10 May 2017

Sue Weatherly
Director Strategic Outcome and Development
City of Parramatta Council
126 Church Street
Parramatta
NSW 2124

**Re: Western Sydney Stadium - Response to Stage 2 DA Comments
Attachment One – detailed Comments
'Stadium Activation'**

O'Connell Place - Everyday Mode

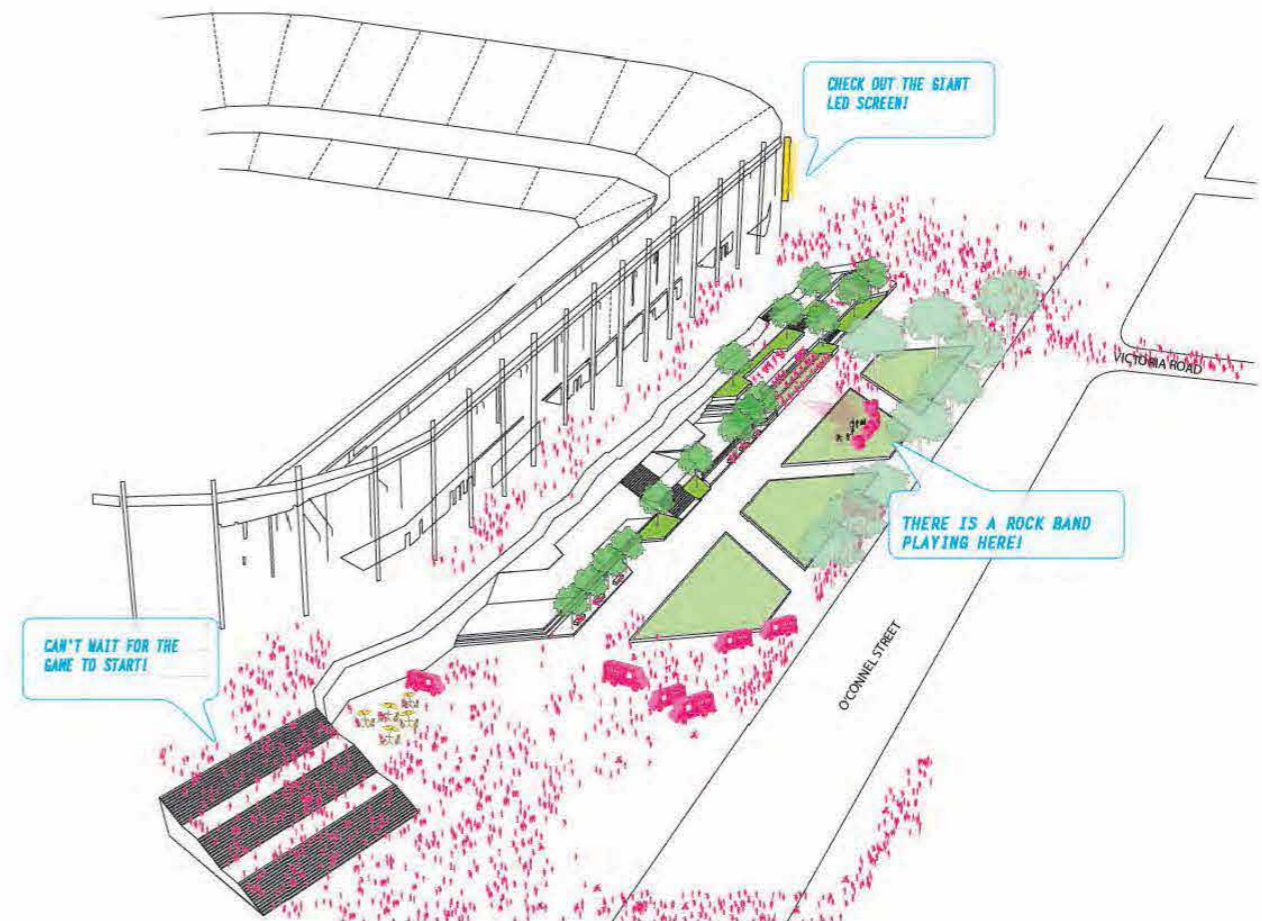
Council has concern that the public domain along O'Connell Street has been designed as a place to only sit and relax, with few activation opportunities. There is one proposed tenancy of external activation of the stadium being the café at the south-eastern corner, the remaining precinct relies on landscaping and terracing to create a sense of activity, visual interest and diversity.

As raised in Council's formal submission for Stage 1 DA, children and young people in particular have low provision of informal active recreation opportunity in the City. Active recreation opportunities, such as outdoor courts and water play features, could be incorporated into these areas.

Furthermore, O'Connell Street has the potential to become a major events space for the City, it is recommended that a more sophisticated program of external activation of the stadium is considered by the applicant. Recent examples include AAMI Park, where the external edge of the stadium facing Olympic Boulevard is activated by sports medicine and sporting club tenancies.

The design of the O'Connell Street forecourt area has been revised to include multi-use half courts, and a terraced area including children's play opportunities.

The children's playground area is envisaged to include to a variety of play elements including, slides, climbing nets, sloped climbing walls, appropriate playground style trampolines, and spinners. These elements will be integrated with the terracing to create a variety of play opportunities and experiences for children across a range of ages, and to minimise the impact of the level change from concourse to plaza. Low steps and bench seating provide places for parents and children to rest and watch the play.

Accompanying these active areas within O'Connell Place is an amphitheatre area with a combination of low grass terraces with integrated seating edges. Both areas provided opportunities for visitors and workers from the

stadium to rest, picnic and observe the passing parade, while the amphitheatre could also be activated for small performances.
